# CITY OF ALBUQUERQUE

May 30, 2023

**Re: New Office/ Warehouse Facility**  
**8401 Firestone Lane NE**  
**Traffic Circulation Layout**  
Architect's Stamp 05-05-23 (C17-D013B3)

Based upon the information provided in your submittal received 05-08-23, the above referenced plan cannot be approved for Building Permit until the following comments are addressed:

SHEET NO.
ARCH-002

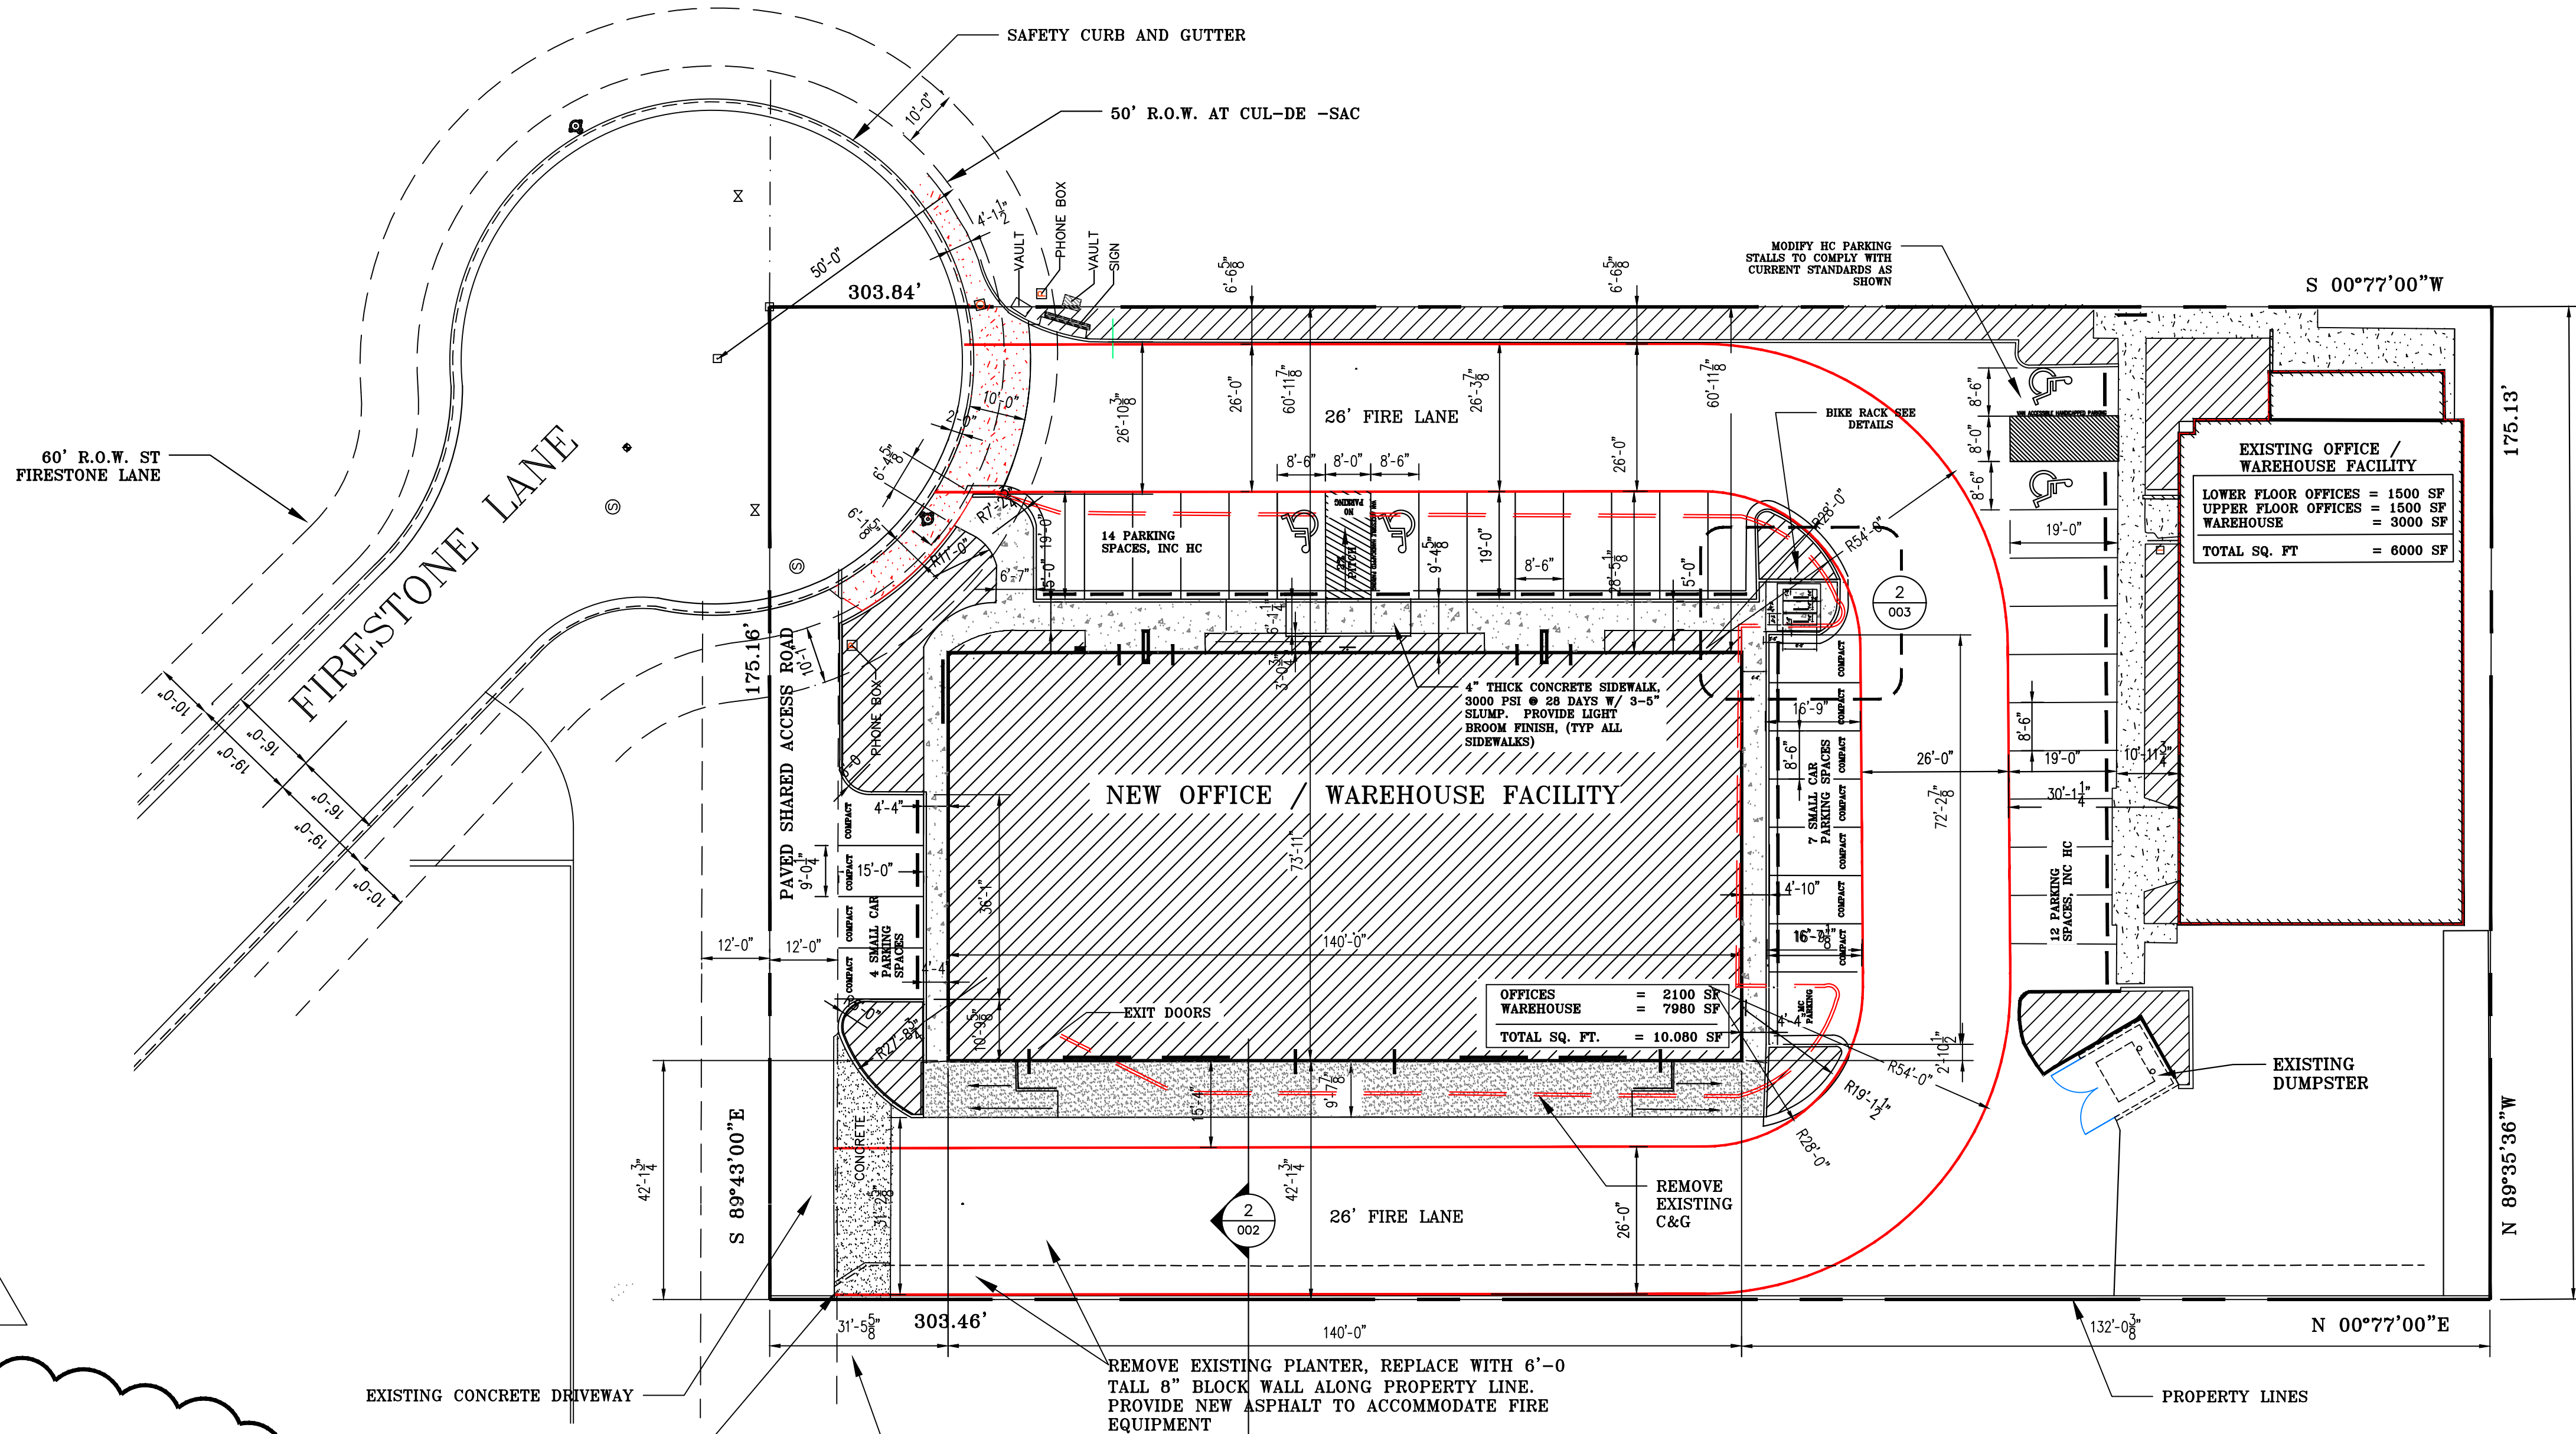
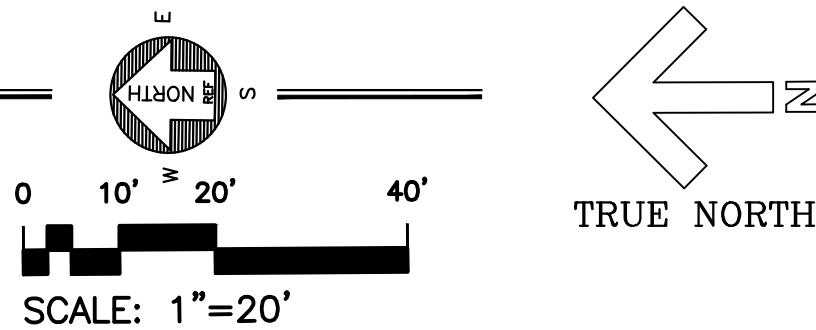
1. Identify all existing access easements and rights of way width dimensions.
2. Identify the right of way width, medians, curb cuts, and street widths on Firestone Lane.
3. Provide site access width.
4. Shared Site access: driveways that straddle property lines, or are entirely on one property but are to be used by another property, shall have an access easement. Please include a copy of your shared access agreement with the adjacent property owner.
5. Provide sidewalk easement. For sidewalk easement, please contact Carrie Mouck at (505)-924-3996, [camouck@cabq.gov](mailto:camouck@cabq.gov)

9. Please provide details for the proposed interior ADA ramps.
10. All bicycle racks shall be designed according to the following guidelines:
  - a. The rack shall be a minimum 30 inches tall and 18 inches wide.

13. Bicycle parking spaces shall be at least 6 feet long and 2 feet wide.
14. Per DPM, a 6 ft. wide ADA accessible pedestrian pathway is required from the ADA parking stall access aisles to the building entrances. Please clearly show this pathway and provide details.
